Permit Number: 041141

has permission to Add 10'4" x 16'6" shed

AT 40 Aldworth St 309 D055001

Dept: Zoning **Status:** Approved with Conditions **Reviewer:** Jeanine Bourke **Approval Date:** 08/25/2004

West Side

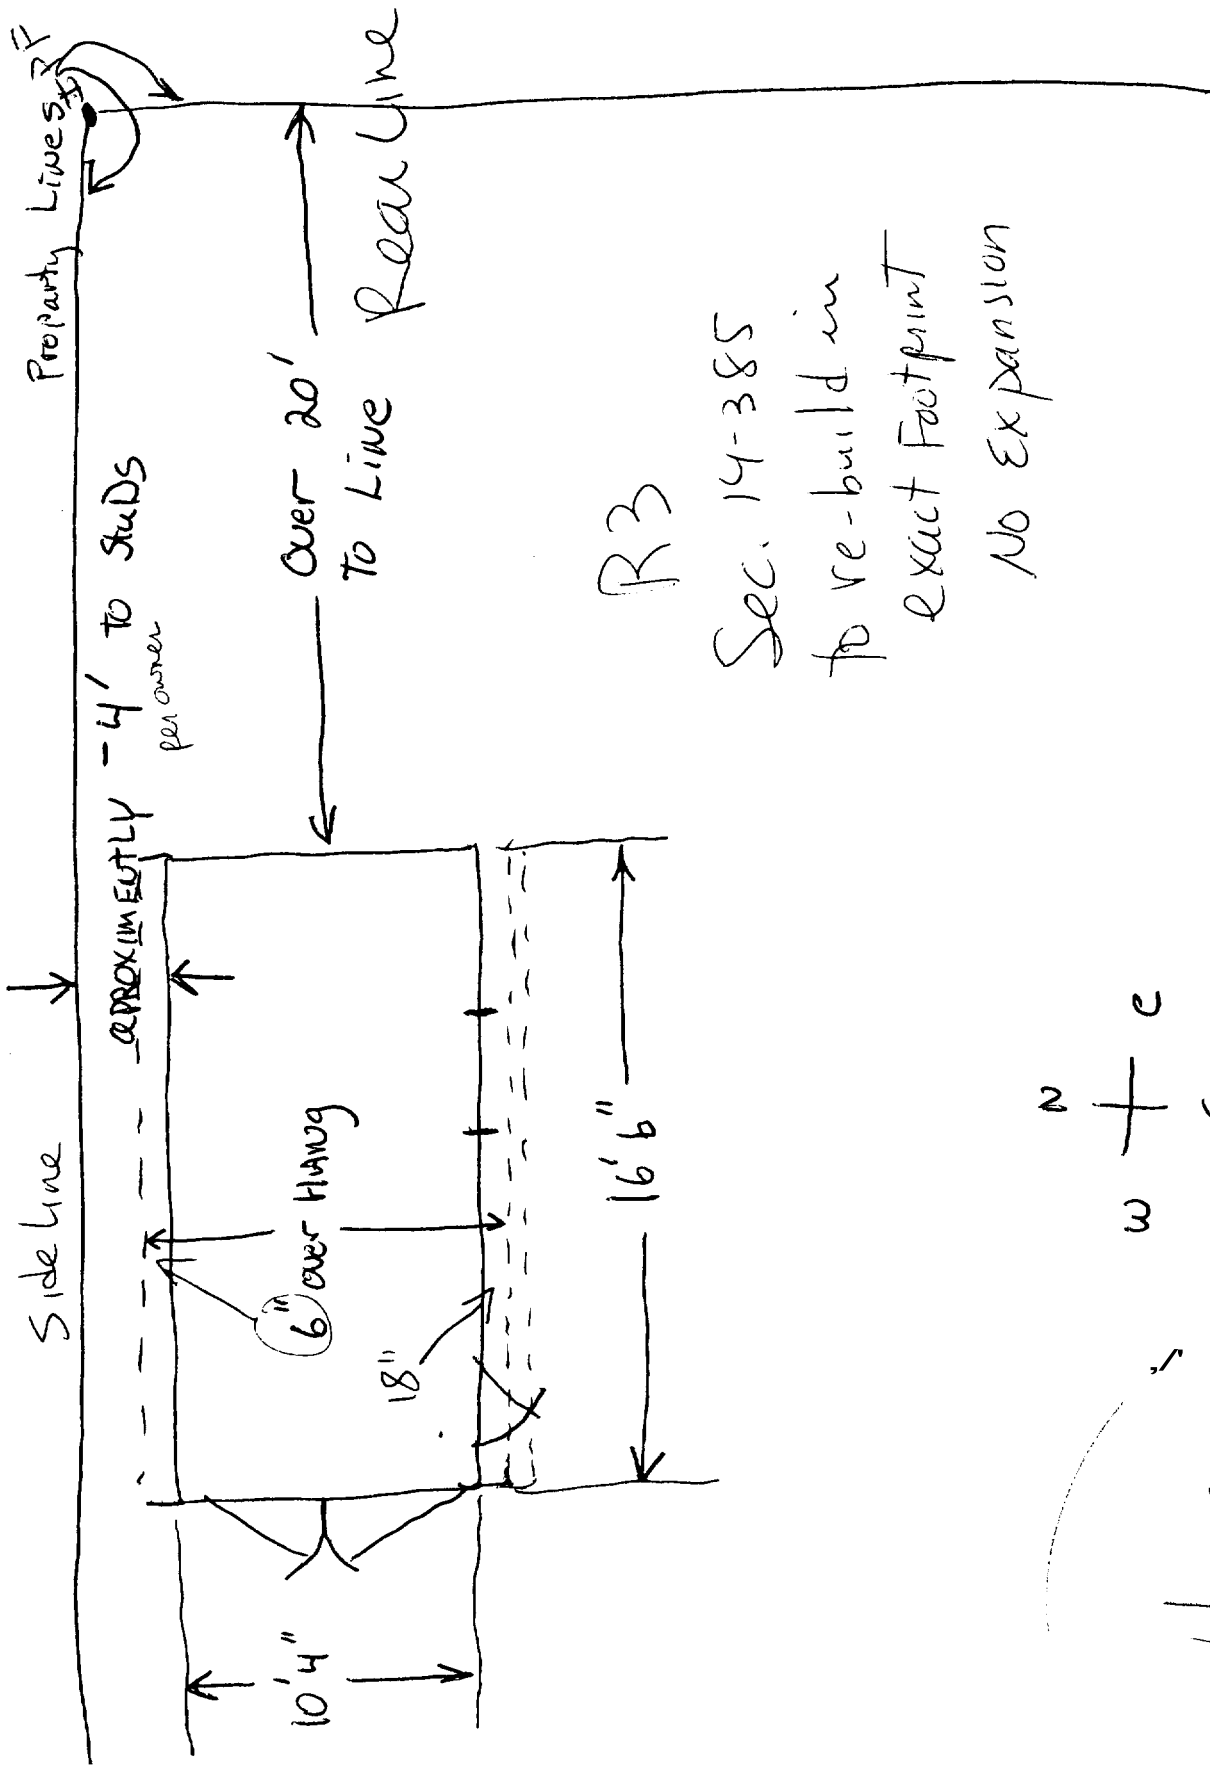
Soffit ok - away from PL & less than 24"

Sec. 14-385
 to re-build in
 exact Footprint
 No Expansion
